Director – Transport Assessments
Department of Planning Industry & Environment
4 Parramatta Square,
12 Darcy Street
PARRAMATTA NSW 2150

13 December 2021

RE: Sydney Metro West – Concept and Stage 1 (major civil construction between Westmead and The Bays) – Modification 2 Clyde stabling and maintenance facility (SSI-10038-Mod-2)

Figure 2-1 Clyde stabling and maintenance facility indicative construction site layout – dive structure (approved project and proposed modification)

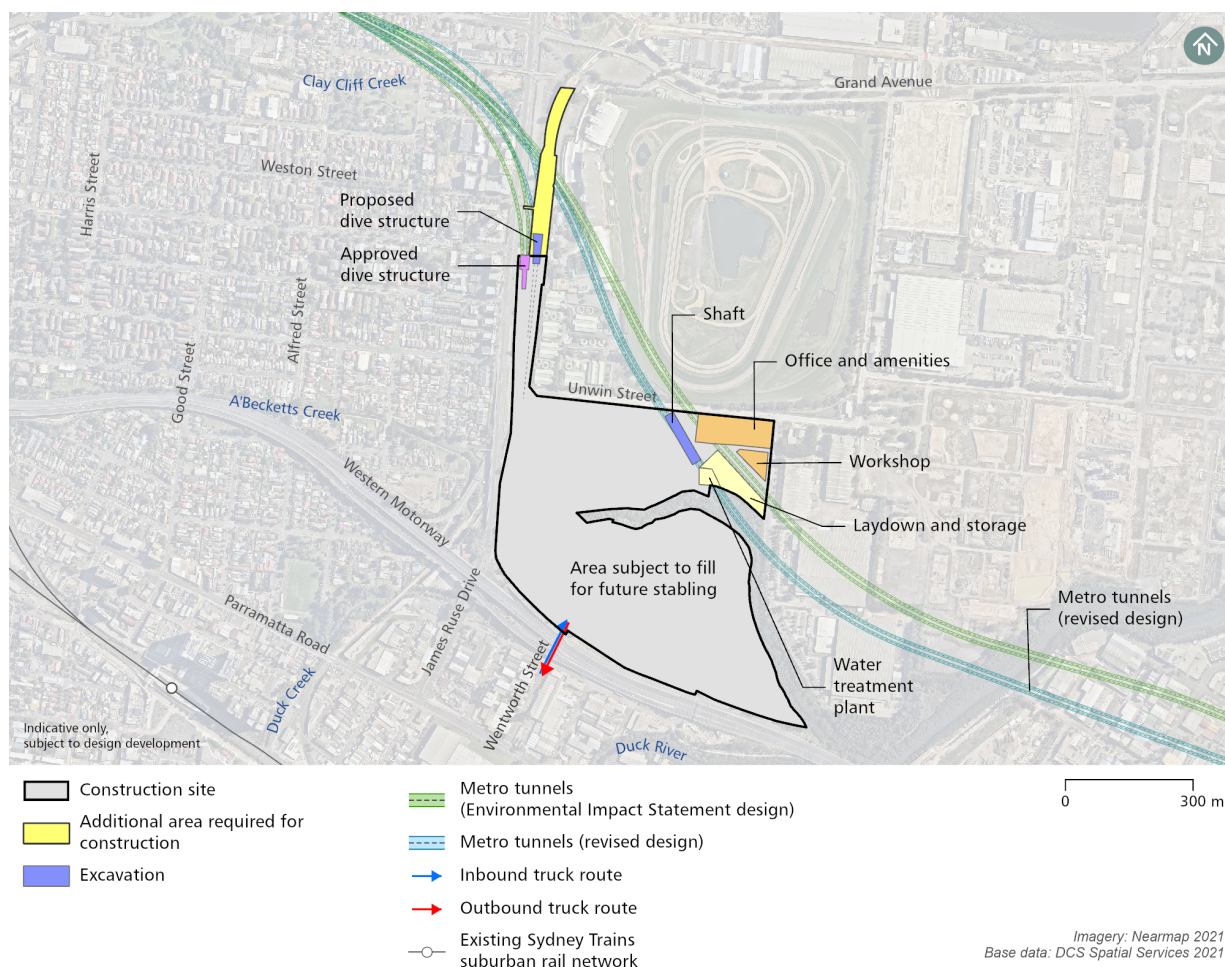
Council officers have considered the proposed modification and note that Council's preferred position remains that the dive structure be moved as far south as possible. The following comments on the proposal seek to address issues arising from the proposal to move the dive structure north and east but Council's position on the preferred location for the dive structure remains unchanged. If despite Council concerns the dive structure is moved the following issues should be taken into consideration:-

- Continued pedestrian access to Unwin Street and the Rosehill Racecourse, with attention to legible and DDA compliant access from the signalised pedestrian crossing of James Ruse Drive and Prospect St

Figure 4-2 Kay Street and Unwin Street route realignment (proposed modification)

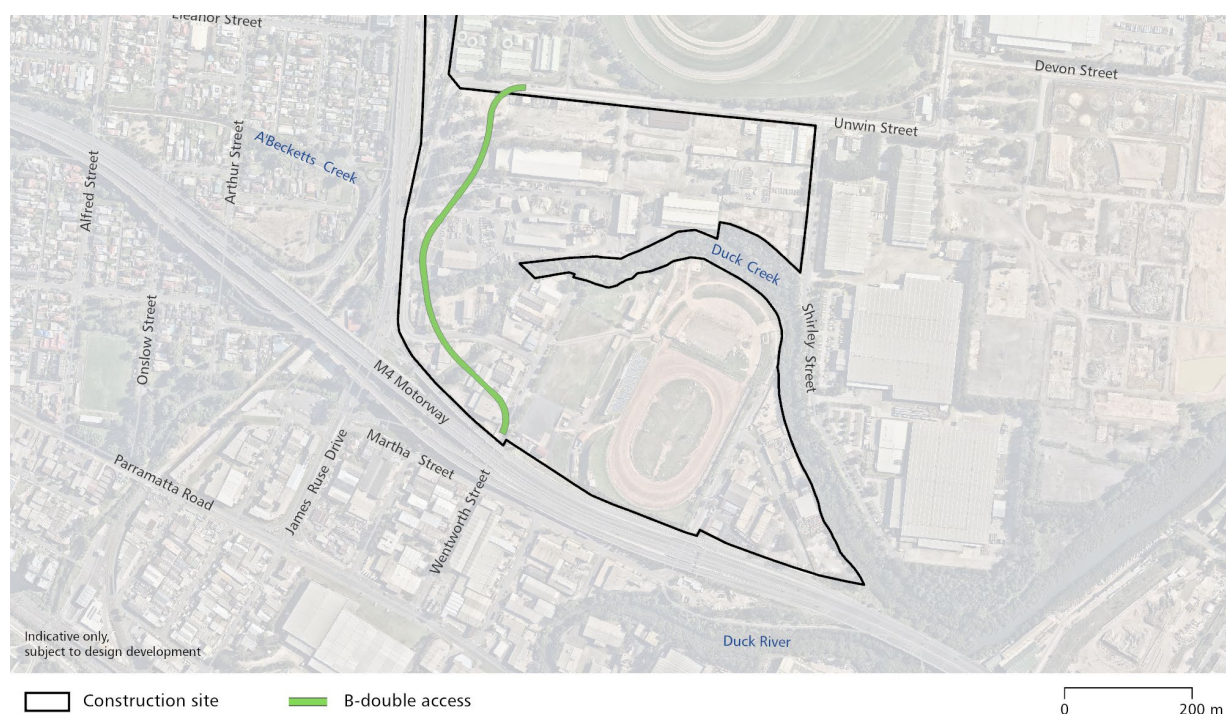
Where there are new crossings proposed, the modification proposal should specify that integrated active transport links opportunities will be considered. Specifically, for Kay and Unwin Streets, if the gradient on Kay Street is significant, Council recommends inclusion of a shared path for cyclists and pedestrians on the western side up to Unwin Street and provision for a footpath on eastern side of the street.

- A regional scale walking and cycling path user path (as discussed by Council in its submission to the SSI) planned along the former T6 rail corridor a of minimum 5m width between Parramatta Road and the PLR ATL at Camellia.
- Realignment of Kay St and Unwin St should accommodate pedestrian and cyclist access to cross James Ruse Drive (such as the current provision through the underpass of James Ruse Drive and the M-4 on ramp connecting to the Transport for NSW Traffic Emergency Patrol Facility on the west side of James Ruse Drive). This connection is the only way for cyclists to connect between the M-4 cycleway and the shared path on the west side of James Ruse Drive. This connection should be maintained during construction and in final design.

Figure 5-14 Potential change in flood levels – one per cent AEP event for the proposed modification compared to existing environment

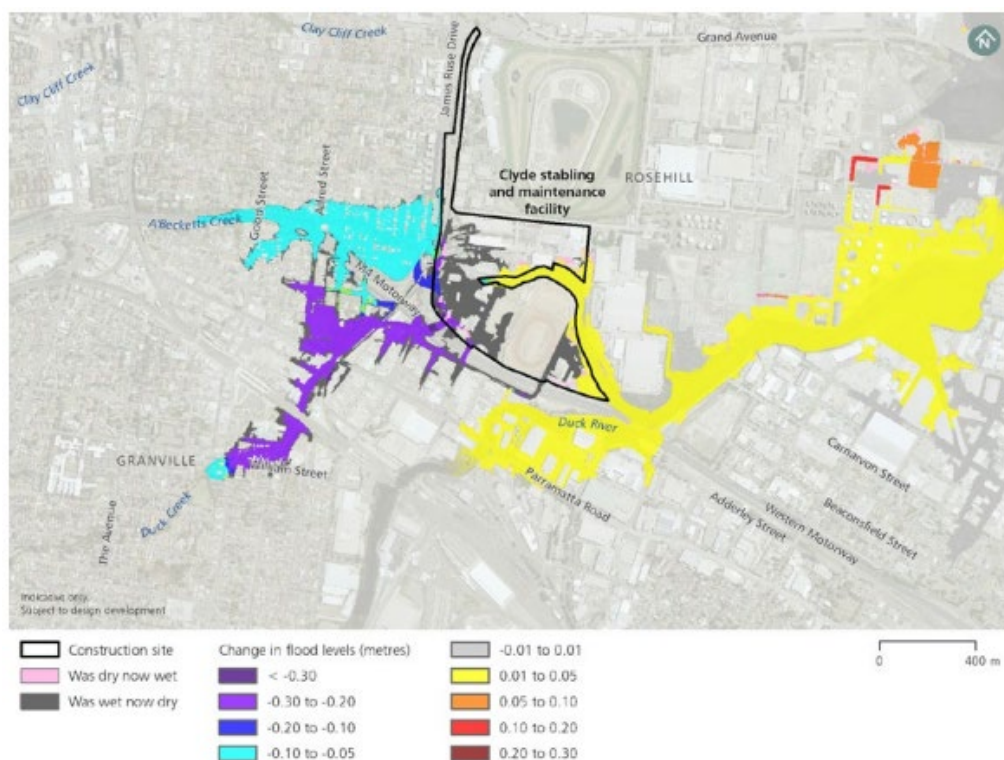
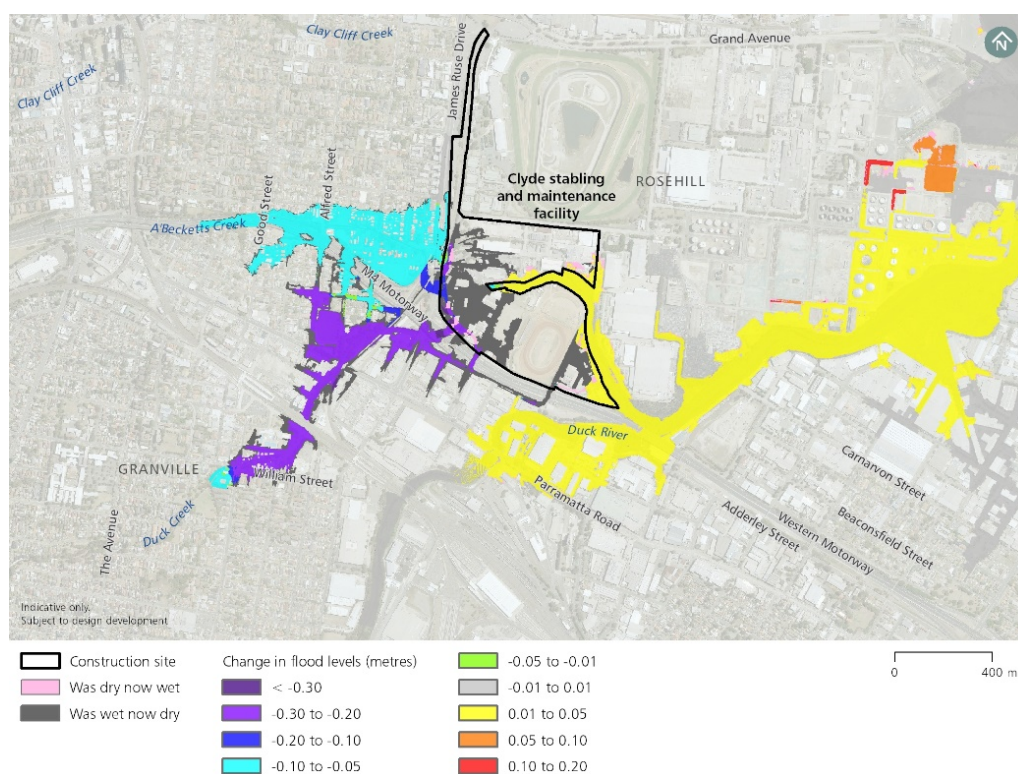
The proposed modification flood report shows negligible impact on hydraulic conditions due to these proposed modifications compared to the previous application. In the previous design the hydraulic model results showed an increase of 80 mm to the upstream and downstream flood levels in Duck Creek at the Clyde maintenance facility in the PMF event. The new modifications show a further 10mm increase to these levels. The modifications also show a 10mm increase in flood levels at the south-western section of Rosehill Gardens Racecourse grounds in addition to the previous reported 40mm increase.

This increase in flood levels have been reported as being due to loss of floodplain storage by up to 10m encroachment into the Duck Creek floodplain due to the bridge approach embankment.

Council recommends that the proponent further investigate alternate solutions that do not result in adverse changes to flood levels or hydraulic conditions that are also environmentally acceptable and address the potential creek erosion issues.
